City of Albuquerque

**Re: Saab Albuquerque Grading and Drainage Plan (C-18/D35)
Engineer's Stamp Dated March 13, 2003**

**Re: AMERICA'S PASSTIME, Grading and Drainage Plan
Engineer's Stamp Date 06/11/2012 (C18/D035)**

**AMERICA'S PASTTIME
GRADING & DRAINAGE PLAN**

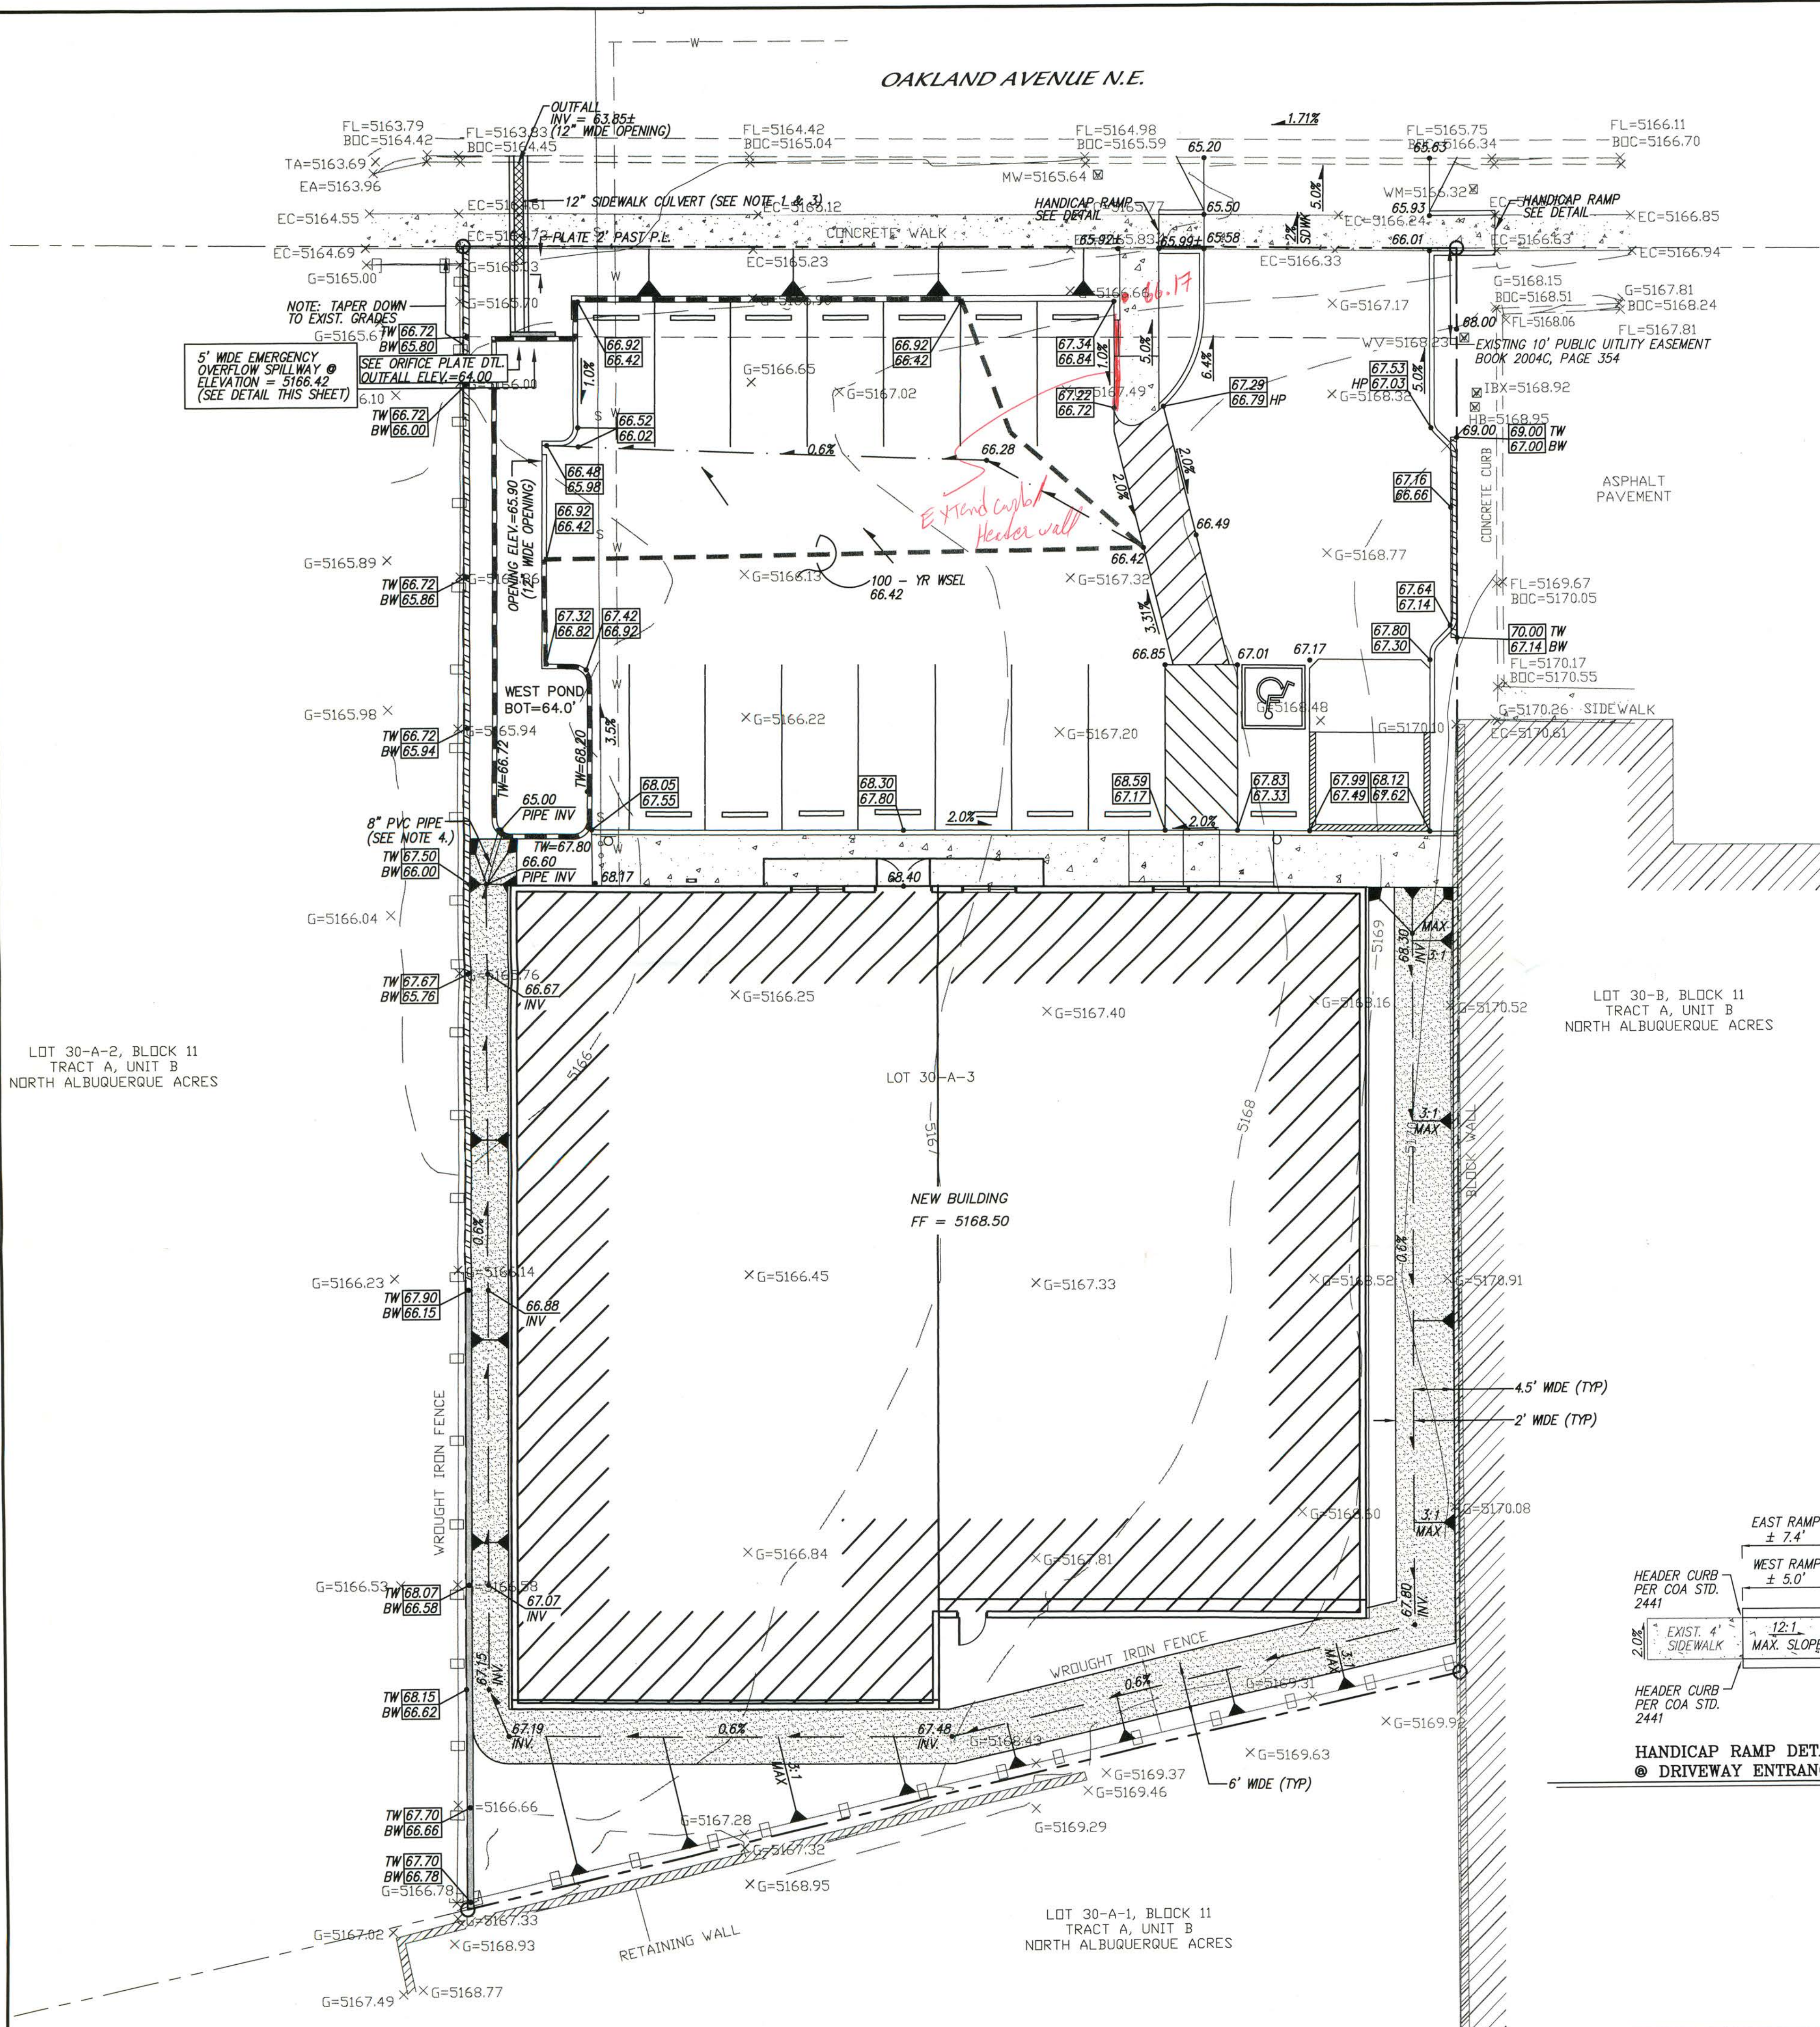
- Include the size for the proposed curb opening at the northwest corner of the northerly parking spaces
- Portion of the proposed detention pond will an approximate 3' cuts into the exiting public utility easement. Can the pond be revised to stay outside the easement?

- Show the proposed Handicap Ramp on the plan.
- An invert of the 66.60 is call out on the plan on the northwest corner of the building. How does the runoff enter the pond from this location? Please provide details. Since the WSEL is at 66.70 please make sure that the runoff will not overflow into the adjacent property. The elevations at the property line may have to be at 67.00 or higher.

- Provide an emergency overflow and calculations for the pond.
- Please provide slope treatment and a typical section for the areas where the grades exceed 3:1 slope. Please check the grades along the easterly property line.

- Make a definite determination if retaining walls are required.
- Change note number 2 under the "Notice To Contractor" to update #8 .
- Hydrology is requesting that proposed landscape areas be depressed.

1. Sidewalk culvert extended 2' and City standard 2236 added as well as tack weld note.
2. 12" wide curb opening size noted on plan.
3. Pond removed from 10' PUE.
4. Handicap ramp detail added to plan.
5. Runoff from side swale enters through an 8" PVC pipe.
6. Emergency overflow and calculations have been added to the plan.
7. Note added for slope treatment on slopes greater than 3:1.
8. Retaining wall notations added.
9. Revised to Update #8.
10. Not sure where landscape areas may be depressed. Landscape areas around the perimeter have swales, but grades are dictated by needing to match back to existing offsite grades.

ORIFICE PLATE/
12" SIDEWALK CULVERT DETAIL

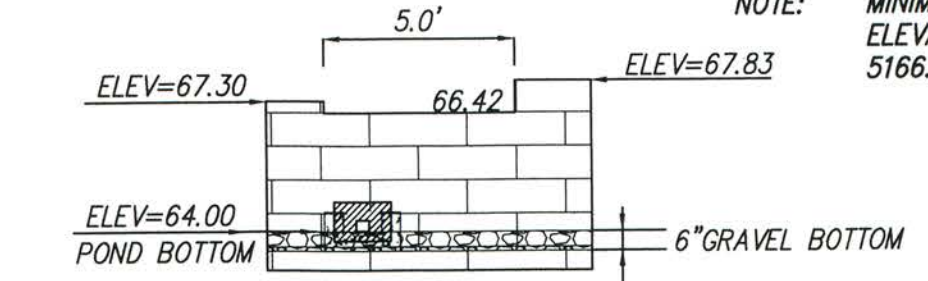
- Sidewalk culvert plate should be extended from the curb to 2' south of the property line. Call out the City of Albuquerque Standard drawing number 2236. Include a note that the contractor will tack weld the bolts on the plate.

- Please revise “(See Note 2)” to “(See Note 1 & 3)” at the 12” sidewalk culvert.
- Is the 8” PVC (with an invert of 66.60) on the northwest corner of the building through a proposed wall? Please provide a detail.

The reference to “Note 1 & 3” have been corrected.

HANDICAP RAMP DETAIL
DRIVEWAY ENTRANCE

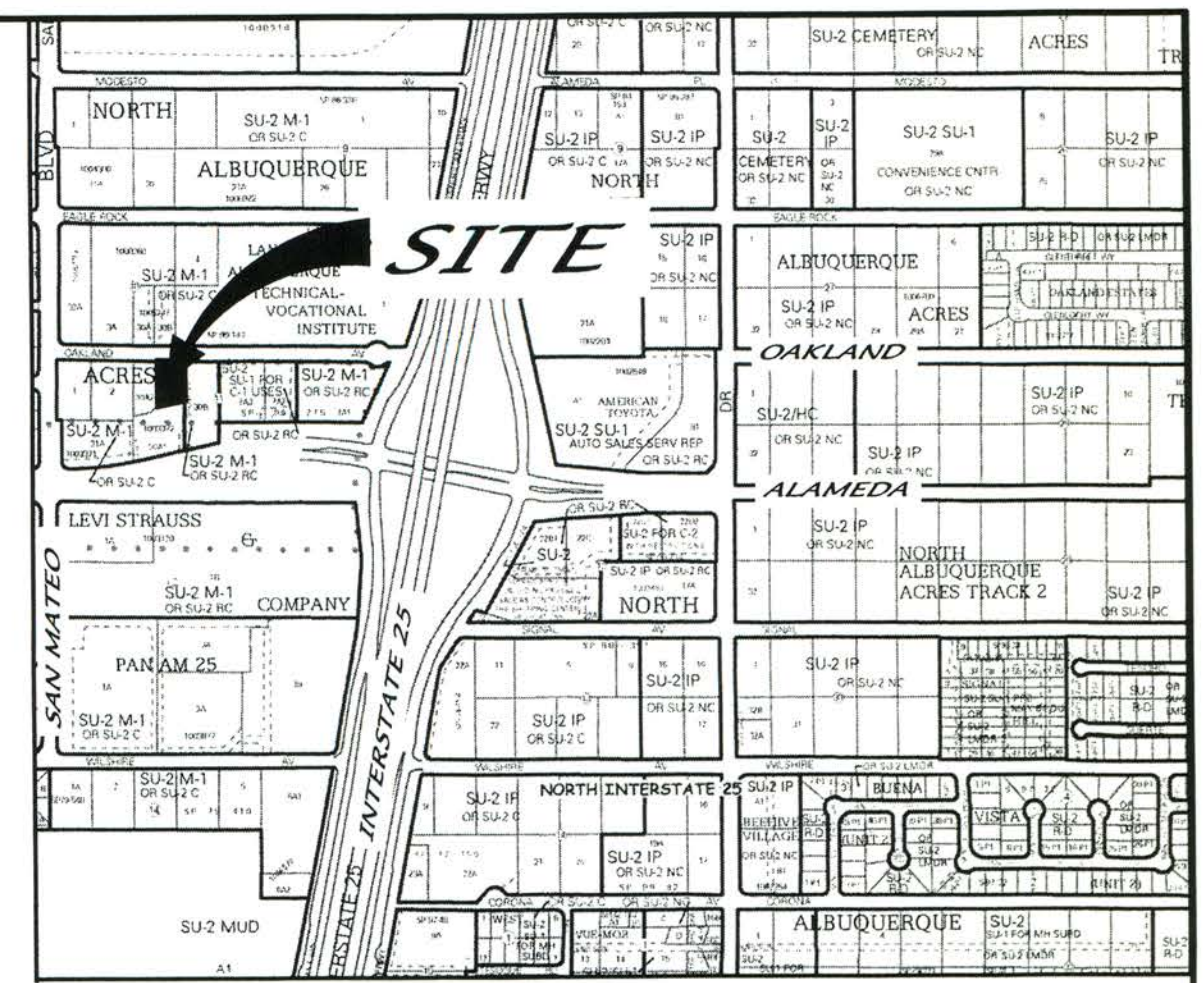
Also, at the DRB last week a new pedestrian connection was shown on the site plan which is not shown on the revised grading plan. Since the entrance grades are over 8% we will need to see the grades along the path to assure handicap accessibility is met.

The handicap parking space into the building is ADA accessible. The sidewalk from Oakland to the building is for pedestrian access only. If you have questions with regards to the ADA component, please call Rick Bennett, the Architect for this project at 242-1859.
